Application by Rosefield Energyfarm Limited for the Rosefield Solar Farm

The Examining Authority's first written questions and requests for information (ExQ1): issued on 2 April 2026

Comments by East Claydon Parish Council

Drawing number	Revision number	Drawing title	Scale
2.1	01	Environmental Considerations	1:25,000 @ A3
2.2	01	Existing Public Rights of Way	1:30,000 @ A3
2.3	01	Topography Plan	1:30,000 @ A3
2.4	01	Field Numbering System	1:30,000 @ A3

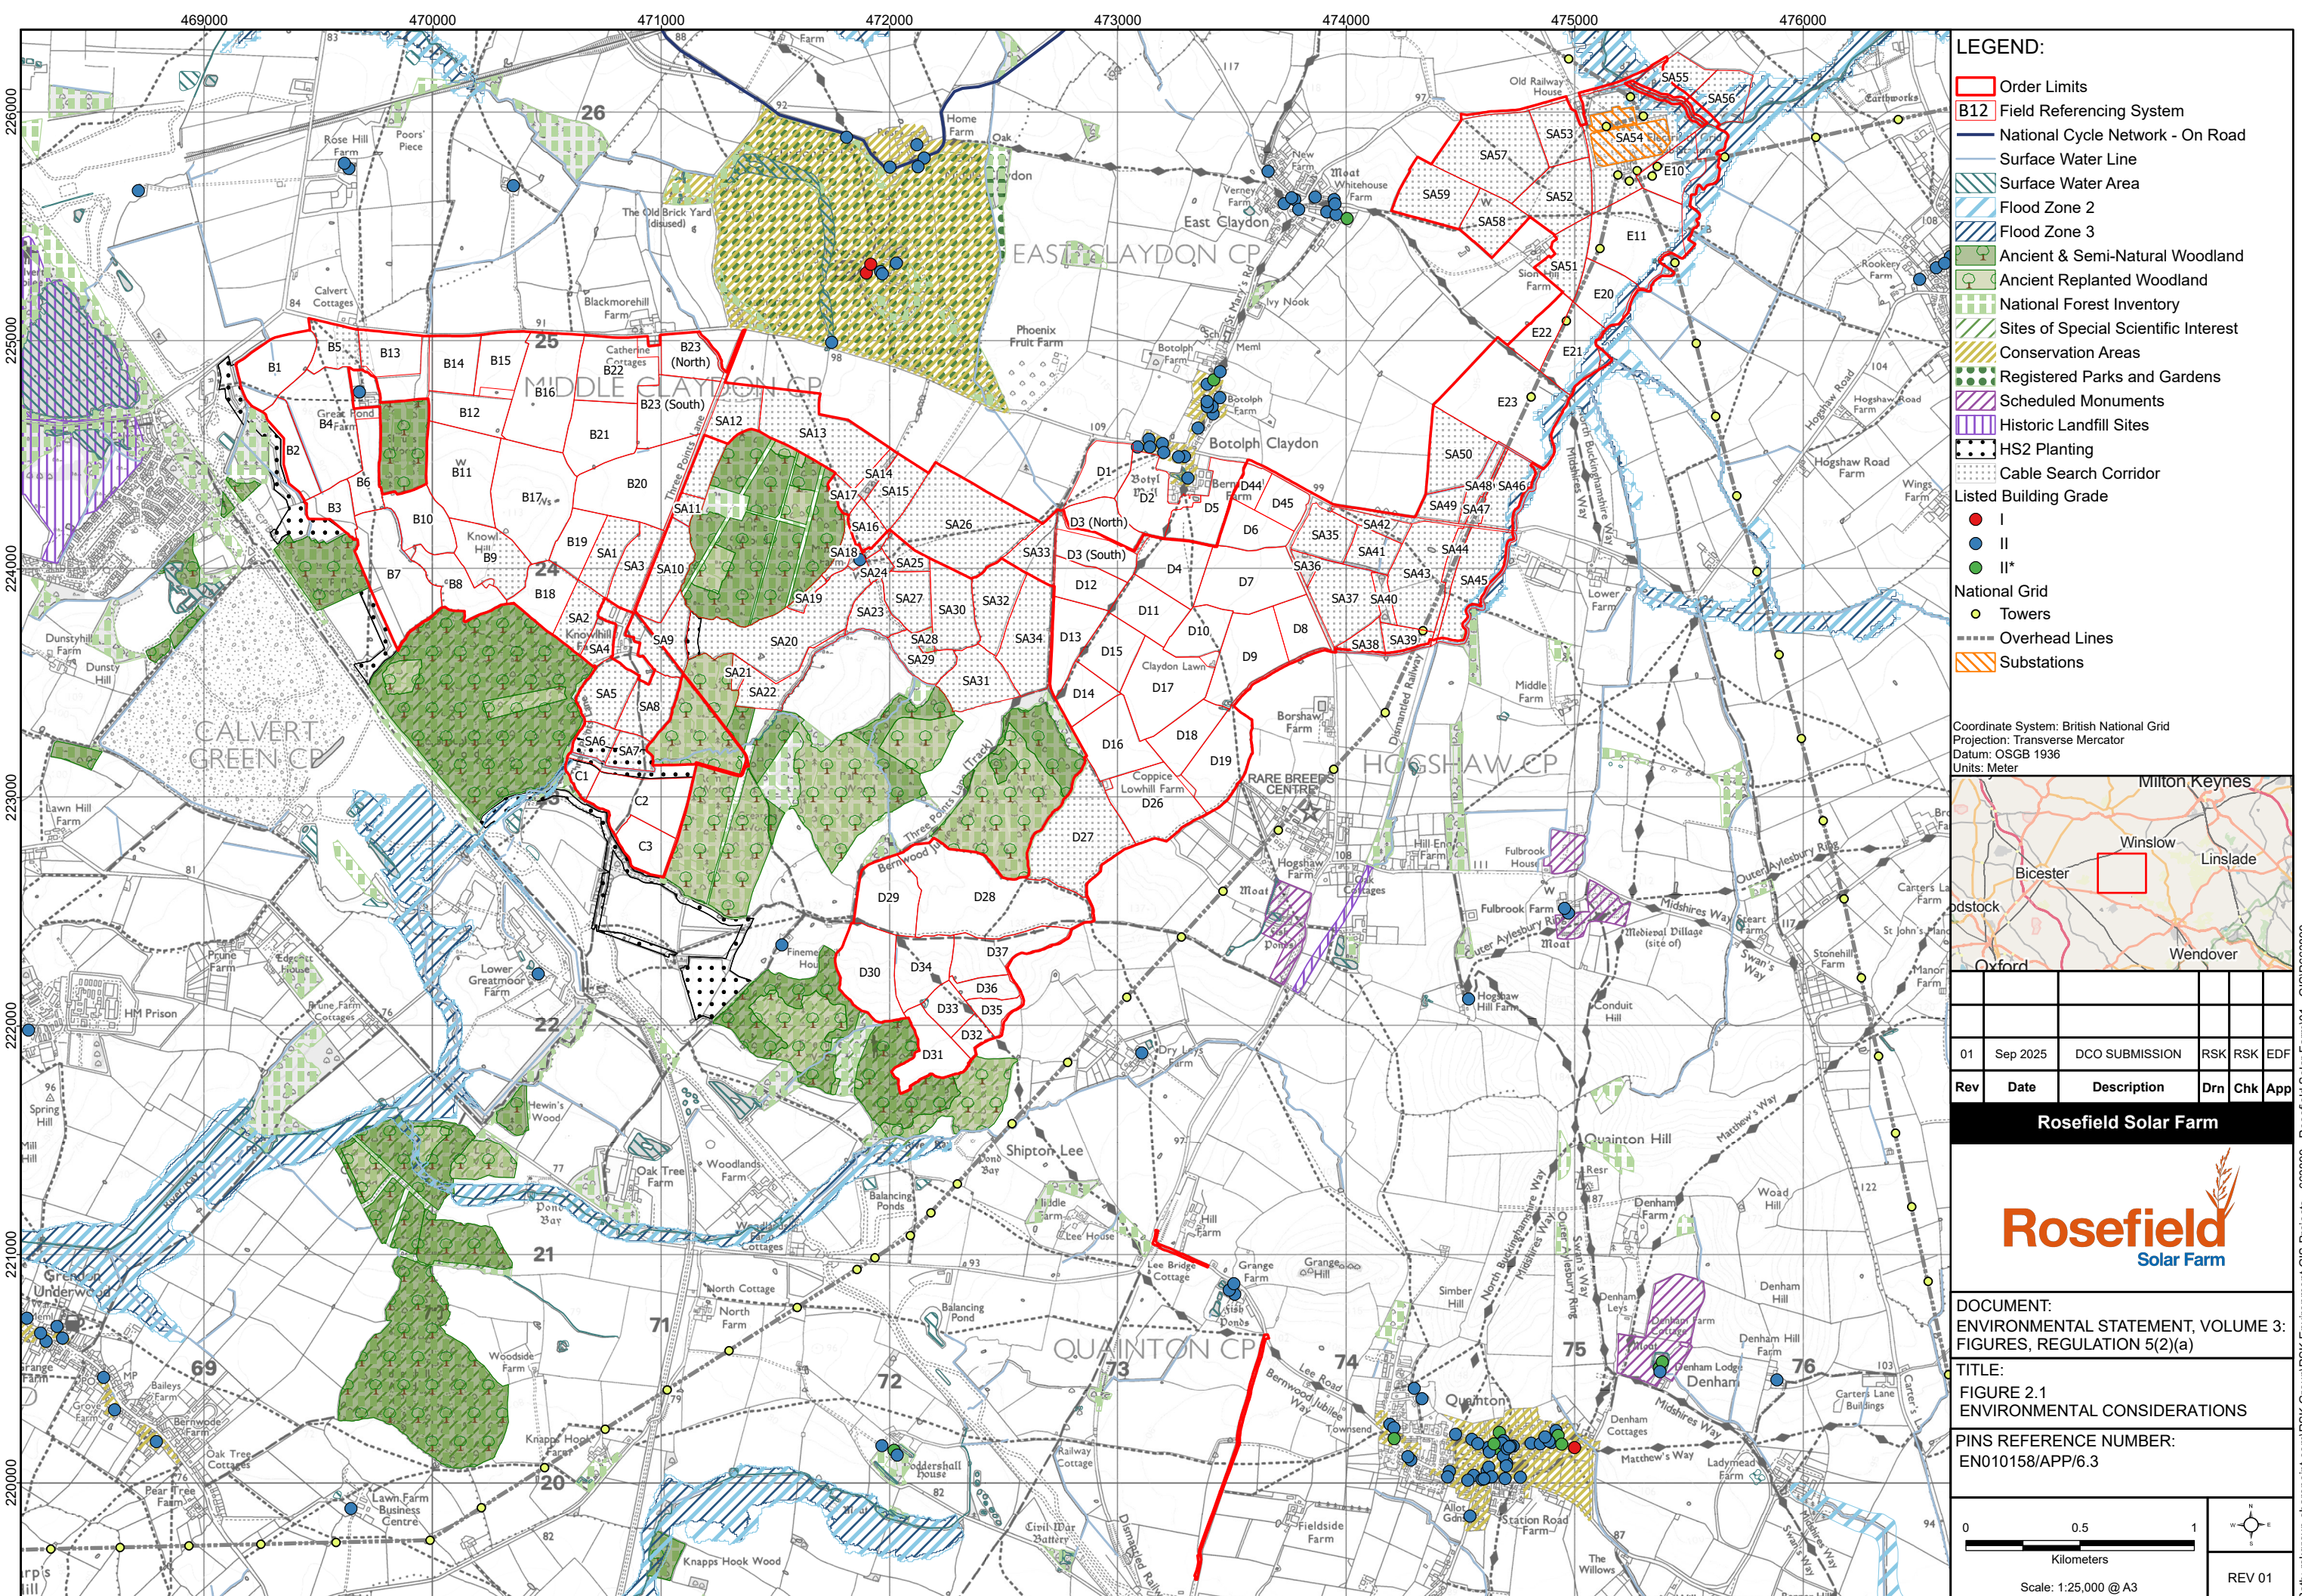
Fig. 2.1 clearly anticipates a cable connection to the proposed replacement National Grid substation. We would ask what surveys has the applicant undertaken in Fields SA51-53 in order to establish the impact of that cable route?
